# CITY OF ALBUQUERQUE

**Planning Department  
Transportation Development Services**

December 14, 2015

**Re: Frank Sanchez Warehouses**  
**2339 2<sup>nd</sup> St., SW**  
**Traffic Circulation Layout**  
Engineer's/Architect's Stamp dated 12-8-15 (M14-D029A)

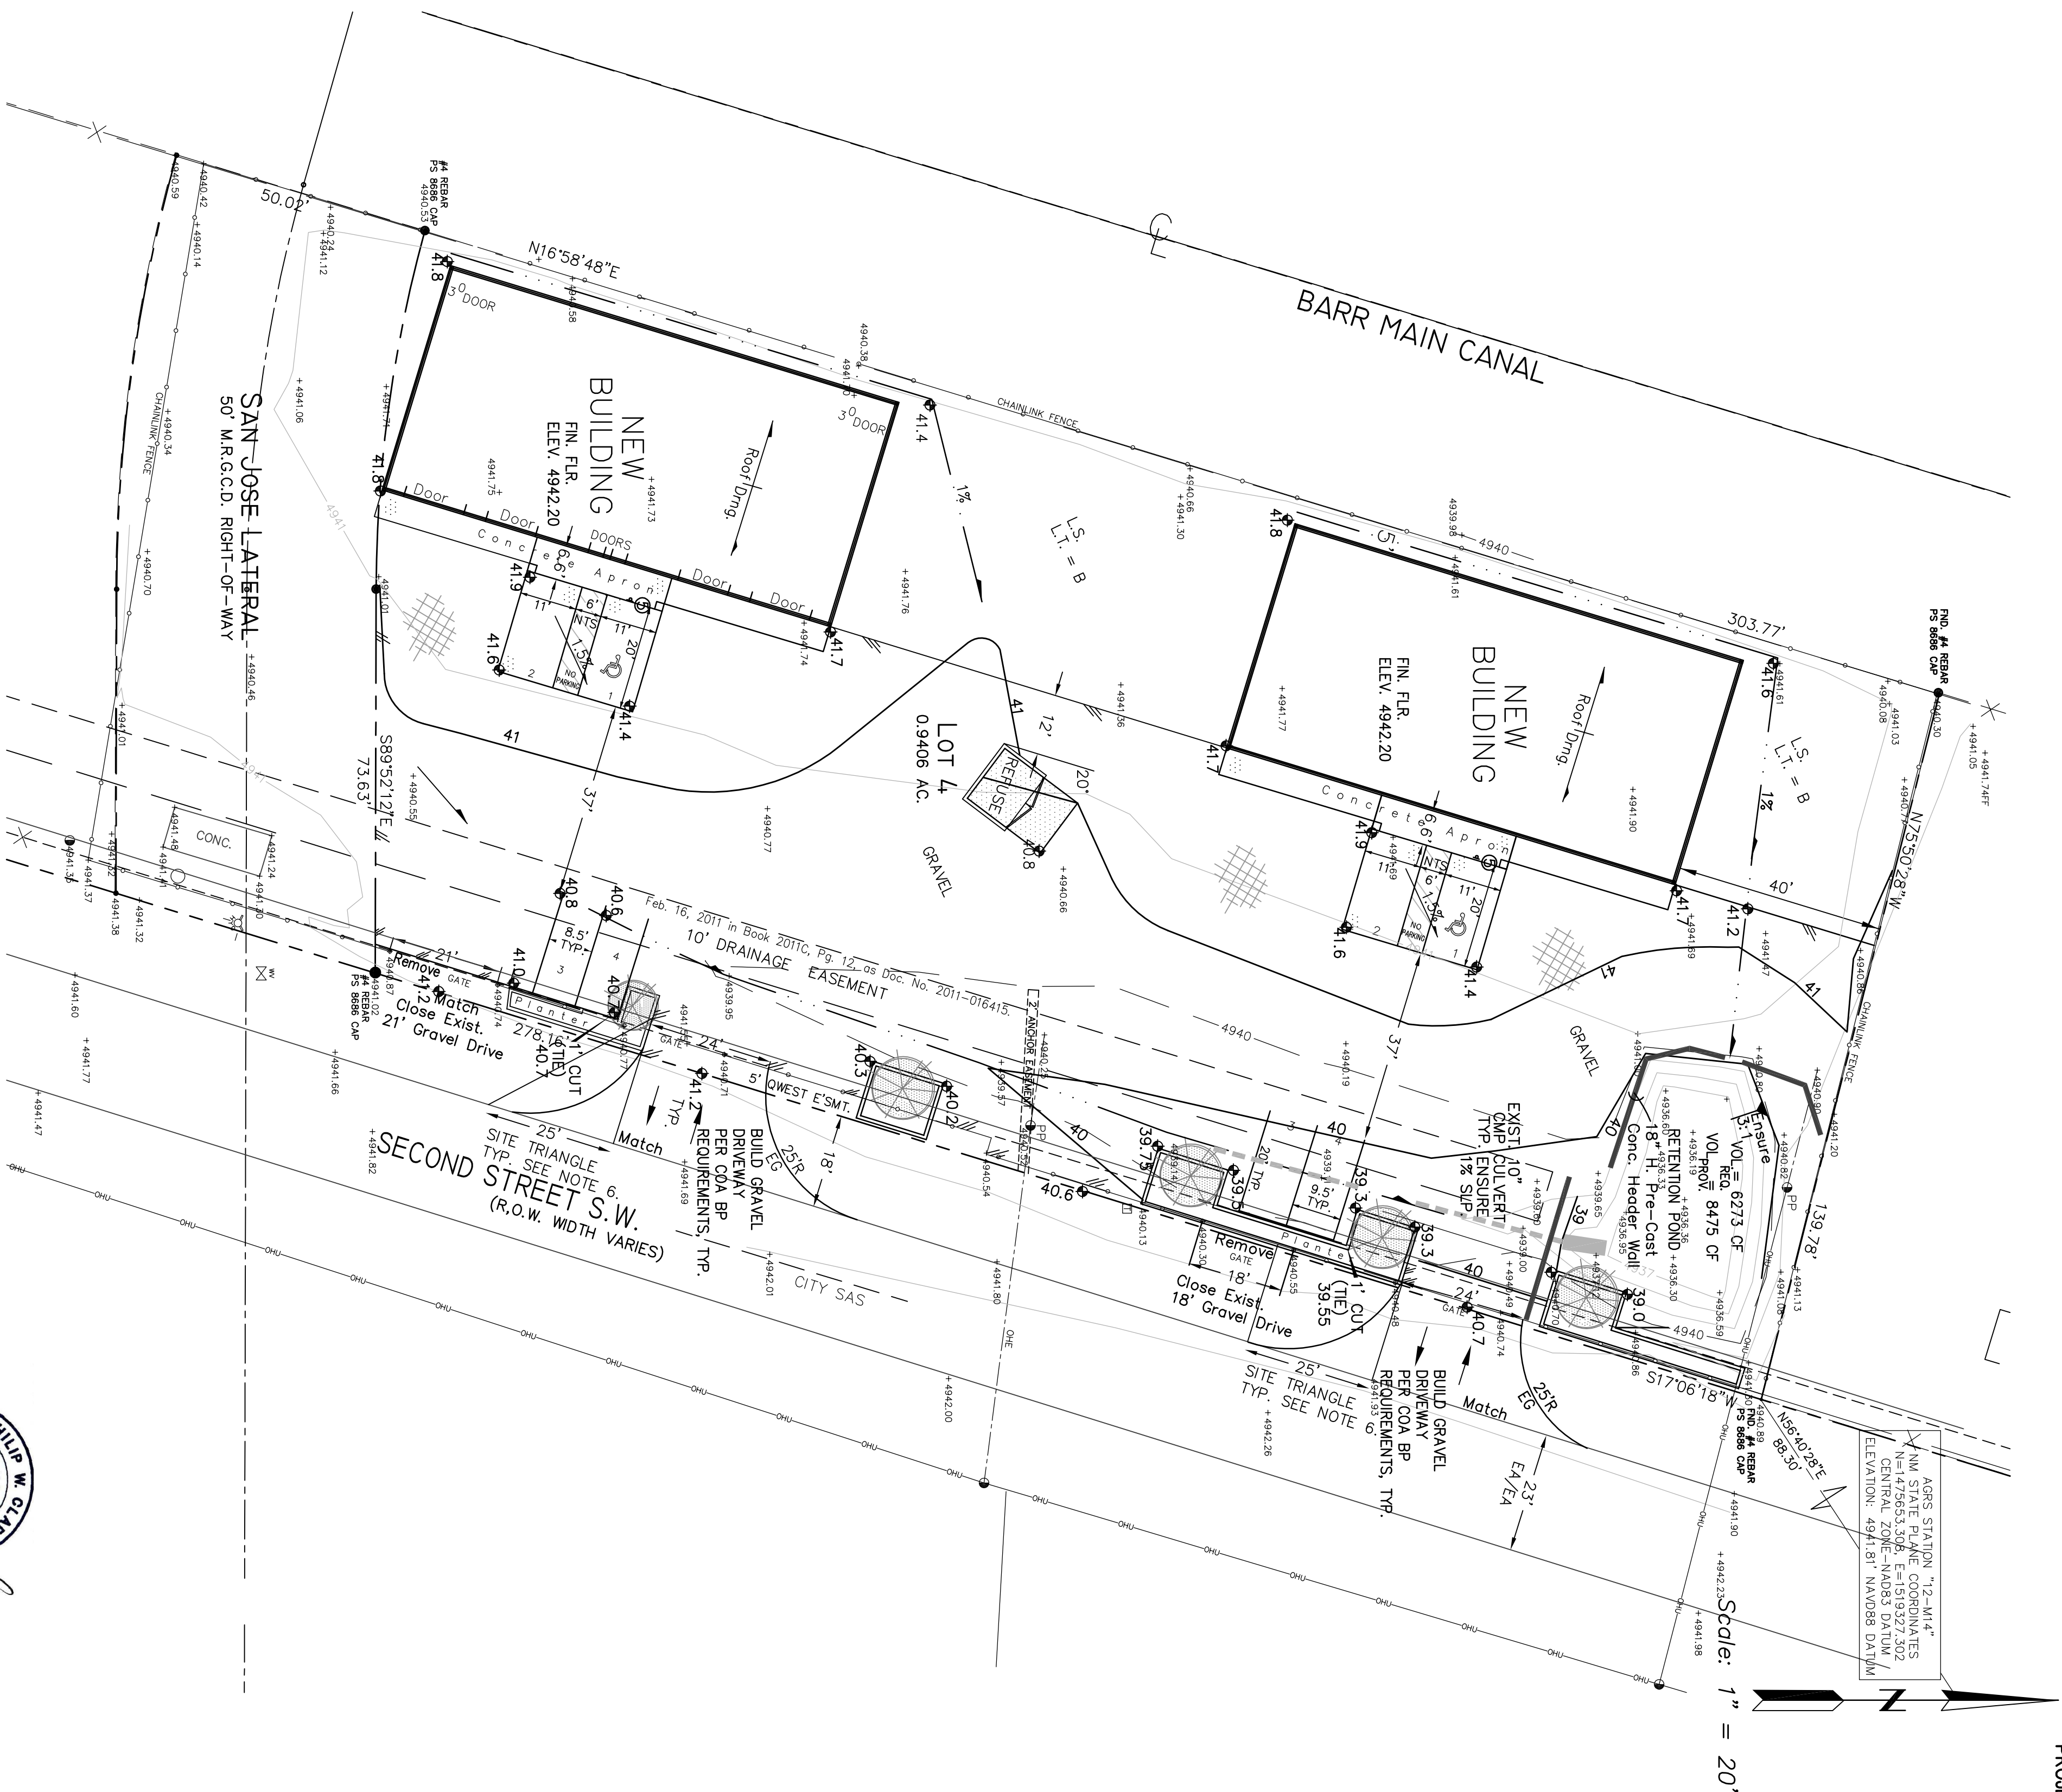
1. Per the DPM, a 6 ft. wide ADA accessible pedestrian pathway is required from the HC parking stall access aisles to the building entrances. Please clearly show and dimension the ADA pathway to each building entrance.
2. Please provide a sight distance exhibit (see the *Development Process Manual, Chapter 23, Section 3, Part D.5 Intersection Sight Distance*). Please show this detail for entrance on 2<sup>nd</sup> St. It appears that the existing trees might interfere with the clear sight requirements.
3. Please include two copies of the traffic circulation layout at the next submittal.
